**MetroLink**

## **Additional Errata Relating to Chapter 20**

Document Title: Additional Errata Relating to Chapter 20

Drawing Title: **Figure 20.6 Land Contamination Sheet 1 of 8**

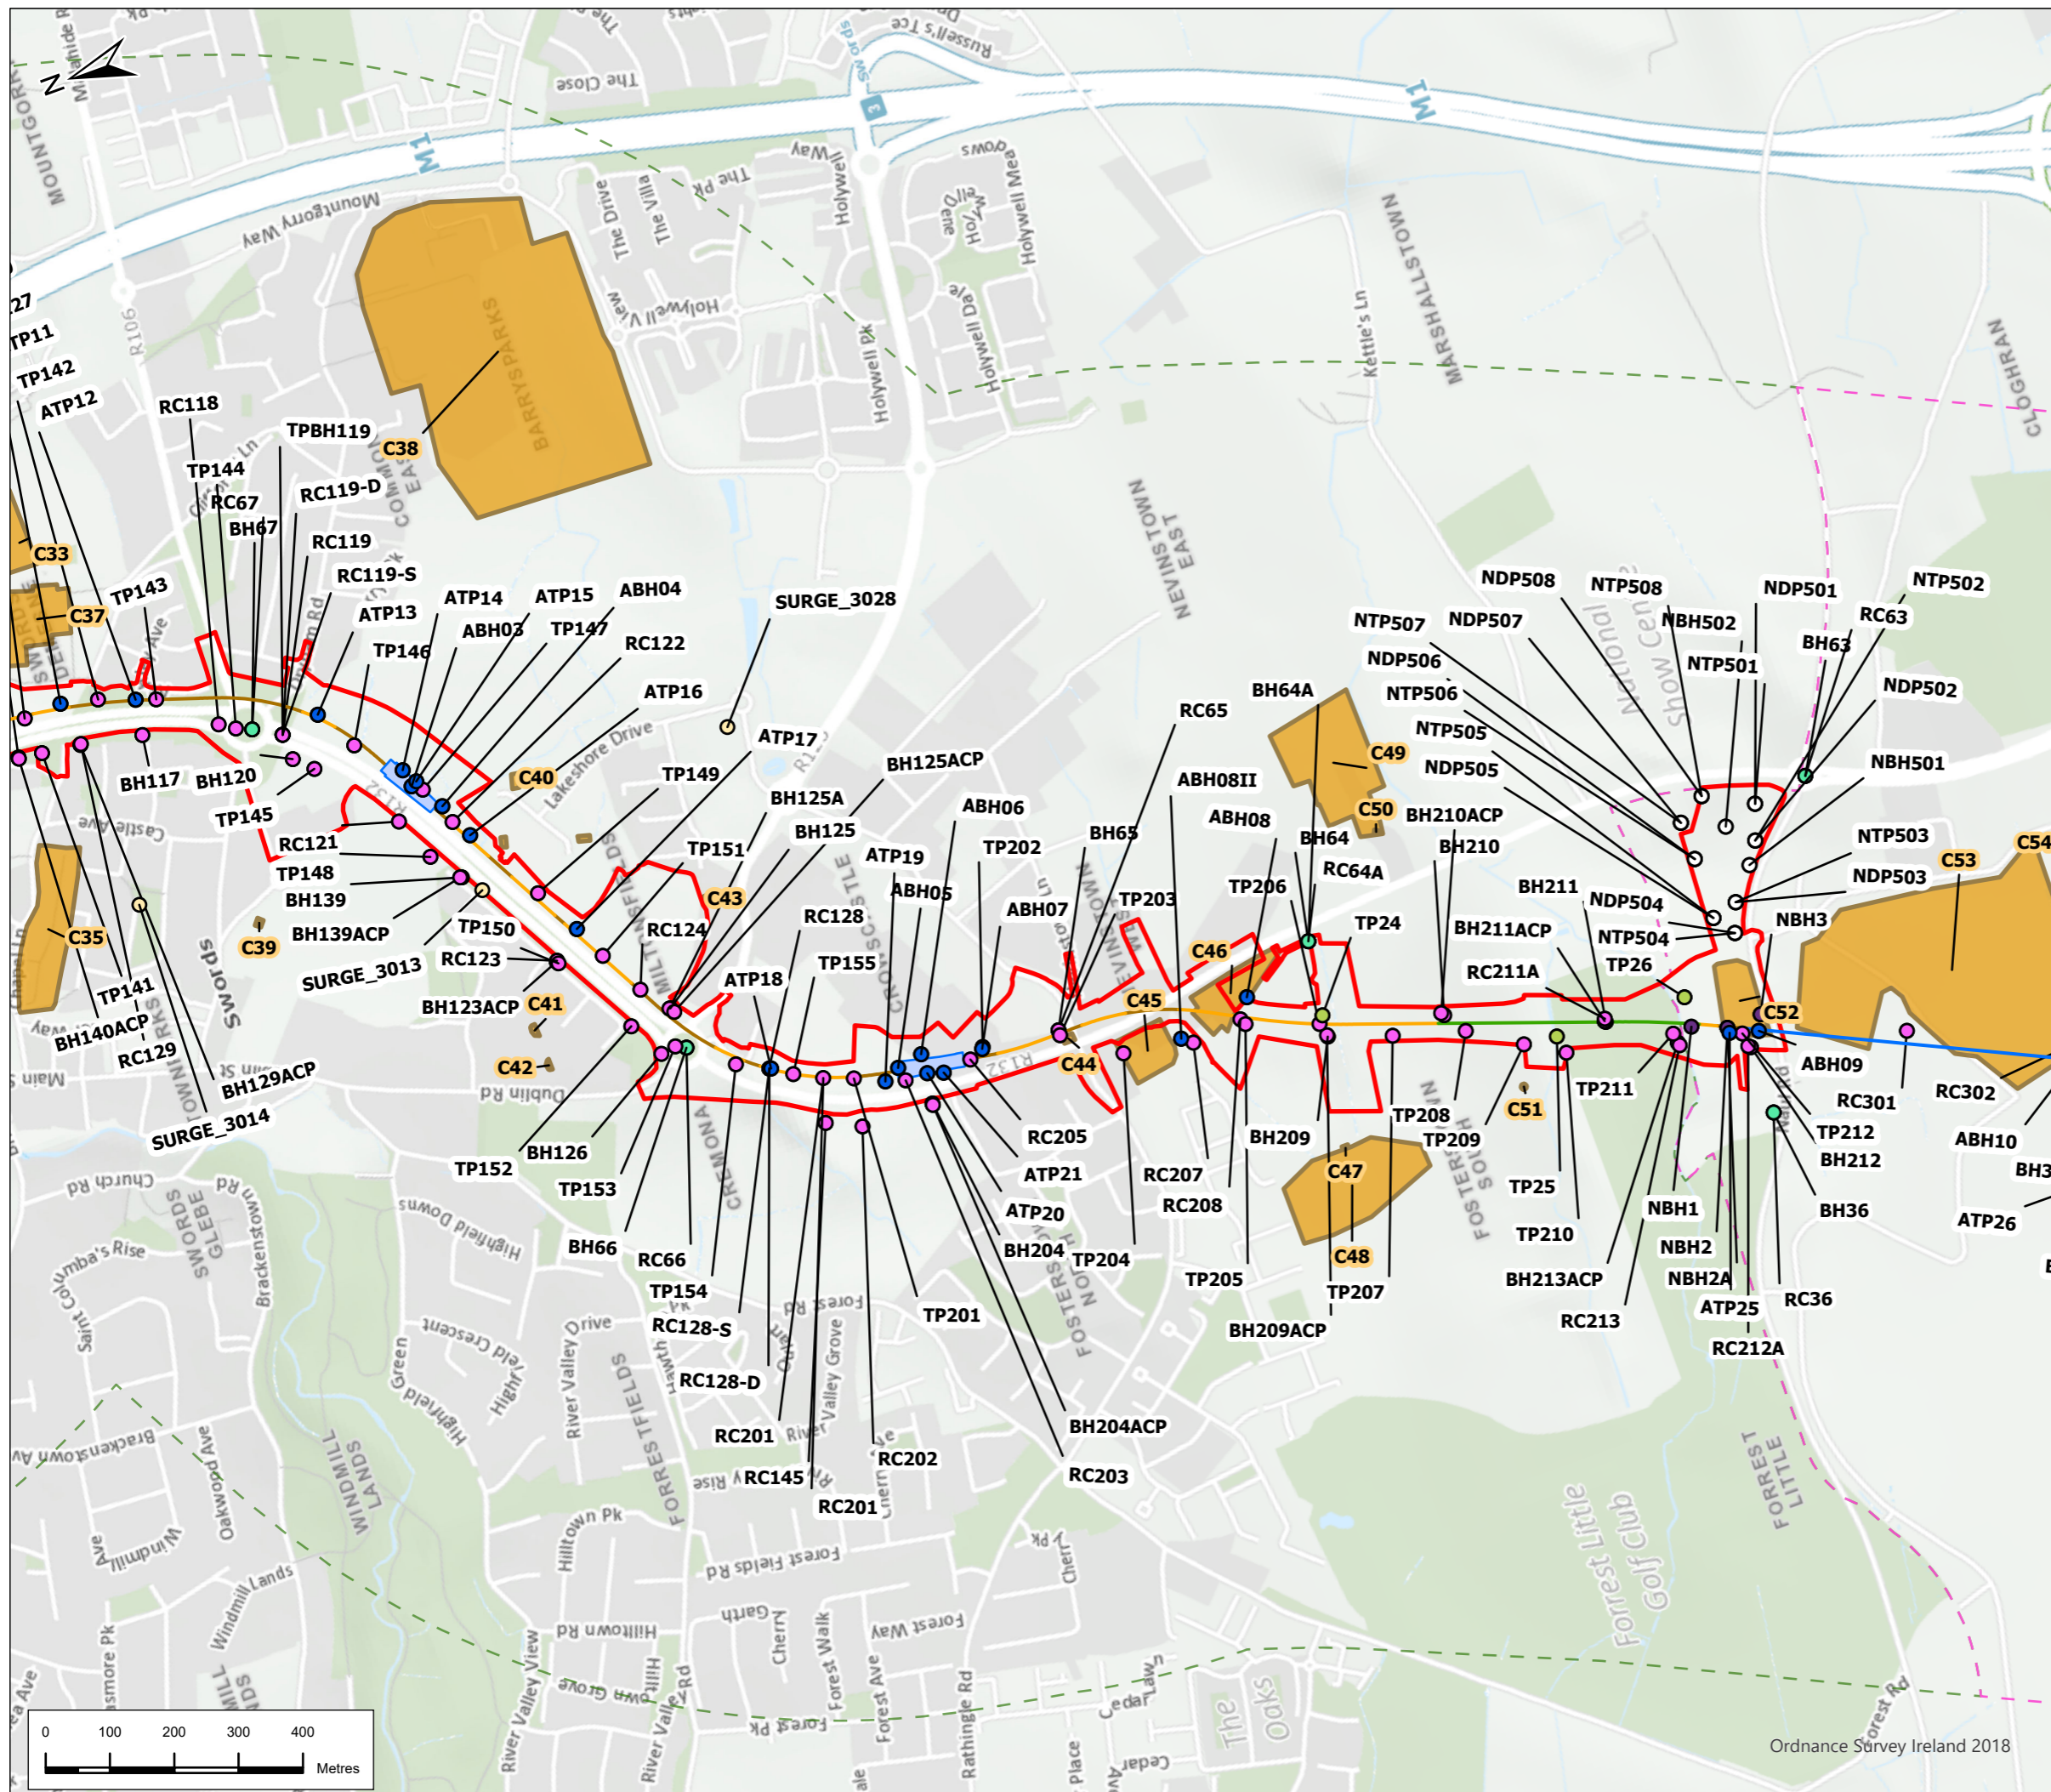
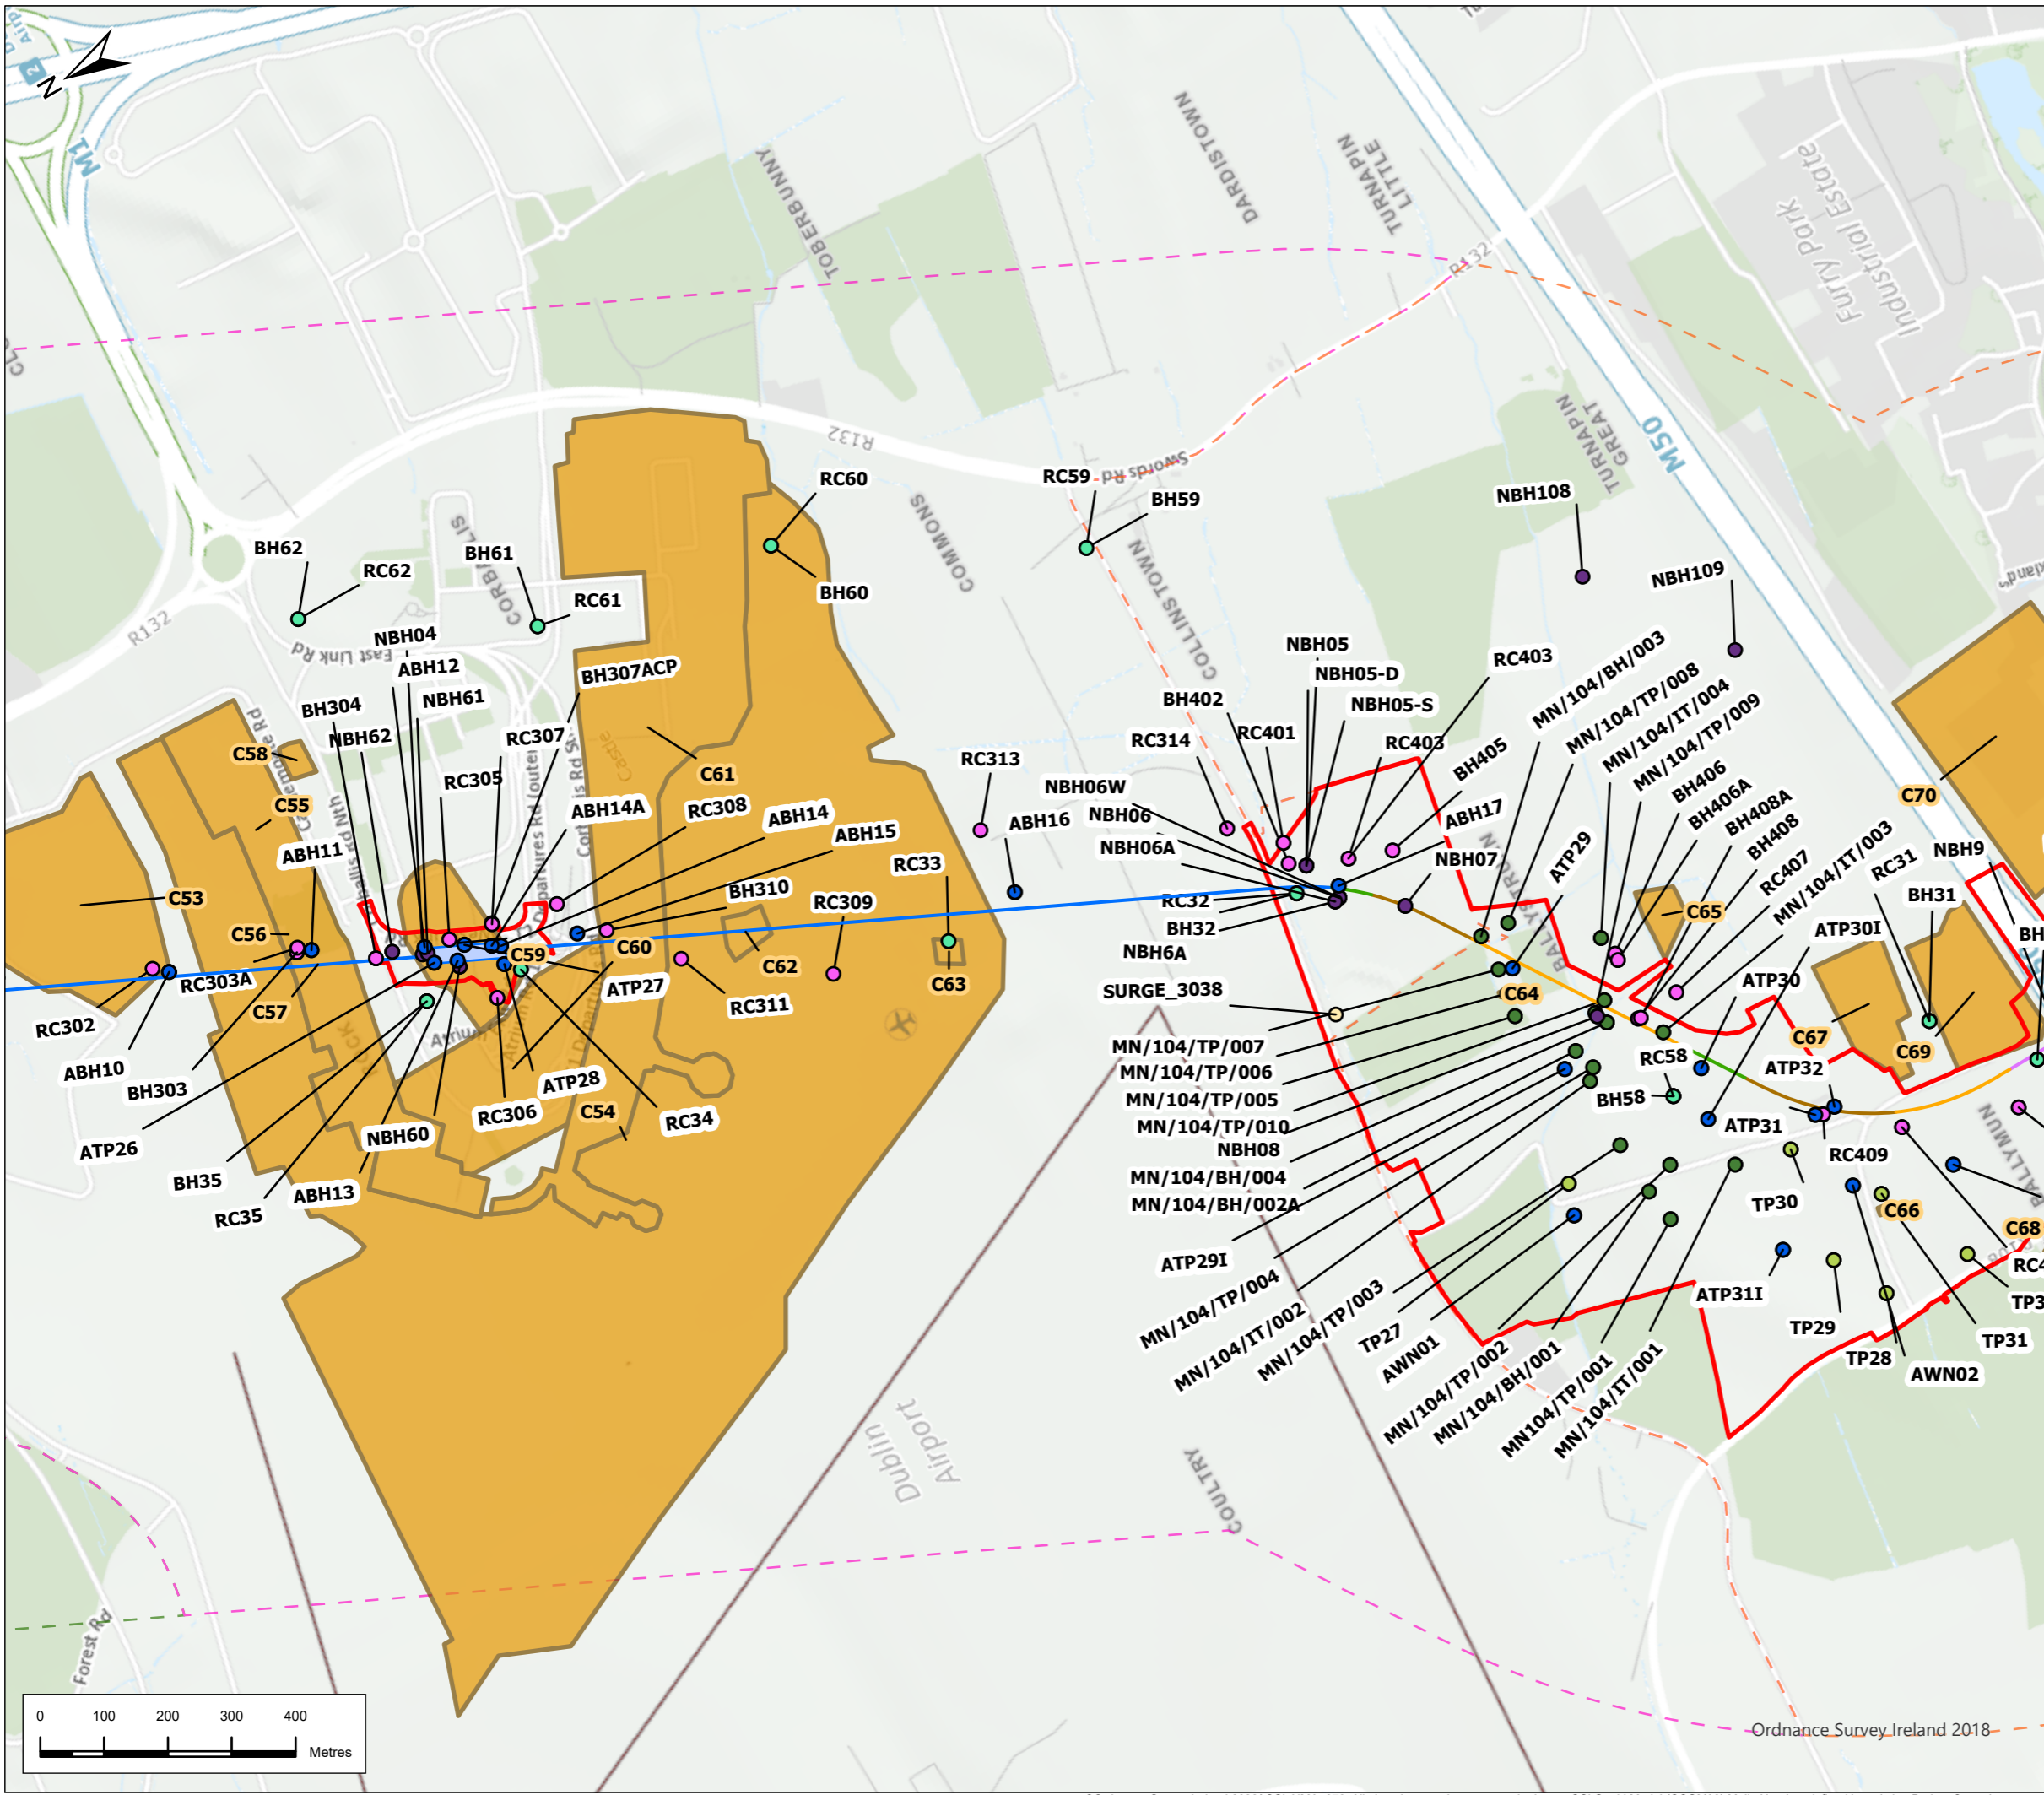
It has become clear during the course of the oral hearing that, in error, borehole locations which appeared in an early drawing of proposed bore hole locations, and which did not form part of the Geotechnical Investigation (GI) scope, were included in error in the chapter presentation as follows:

- Figure 20.6 (Revised version attached)
- Appendix A20.1 (Summary of Supporting Ground Investigation Scope)
- Appendix A20.2 (Summary of Relevant Exploratory Hole Locations and Monitoring data)
- Appendix 20.8 (Appendix A Tables A1 to A4) and Figure 20.6.

Chapter 20 includes summaries of the ground investigation (GI) data used in development of the assessment as detailed above as well as a figure detailing the GI locations. An error has been identified whereby proposed borehole locations which were not actually drilled were included in the summary tables detailed above and Figure 20.6. These borehole locations were not drilled as they were not required. The proposed Phase 1 borehole references included in error are listed in Table 1.

The inclusion of these proposed GI location references was mistaken, and it should be noted that boreholes at these proposed GI locations were not drilled. Consequently, there is no data associated with these proposed locations.
